El Paso County

Grandview Metro District Project 1041 Submission

August 6th, 2021

Exhibit 1

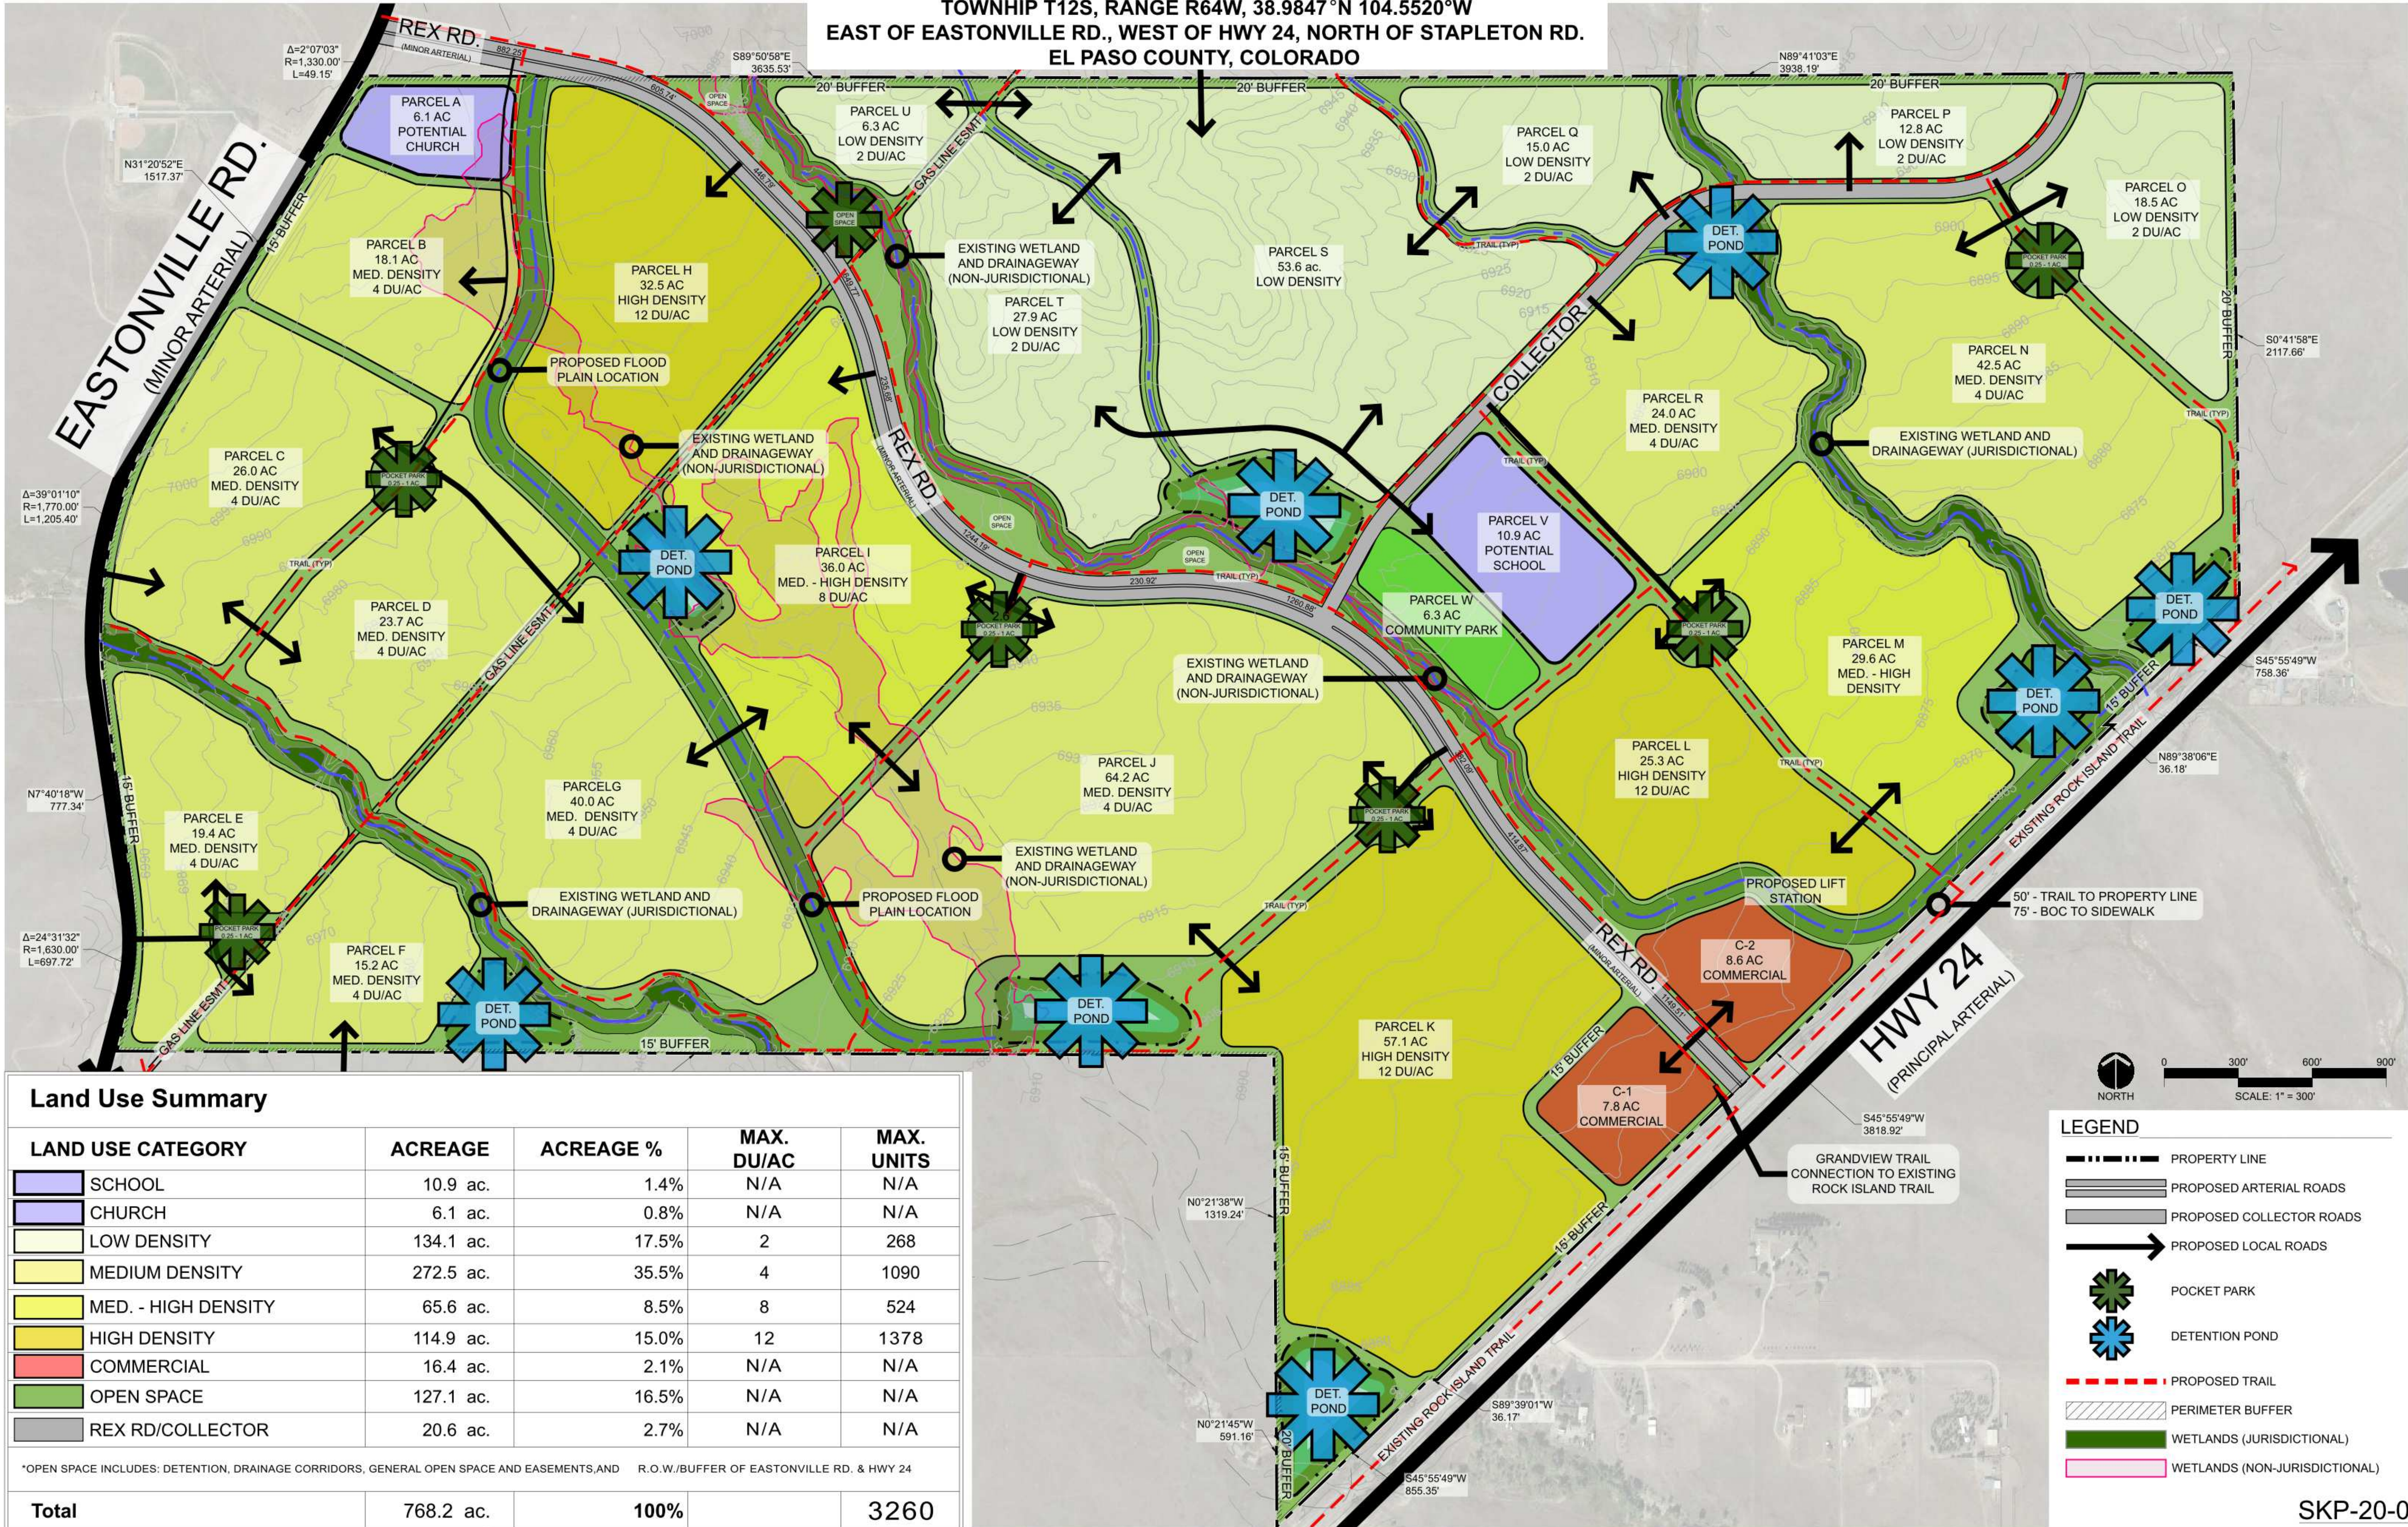
what is name of exhibit L-is that th sketch plan as approved?
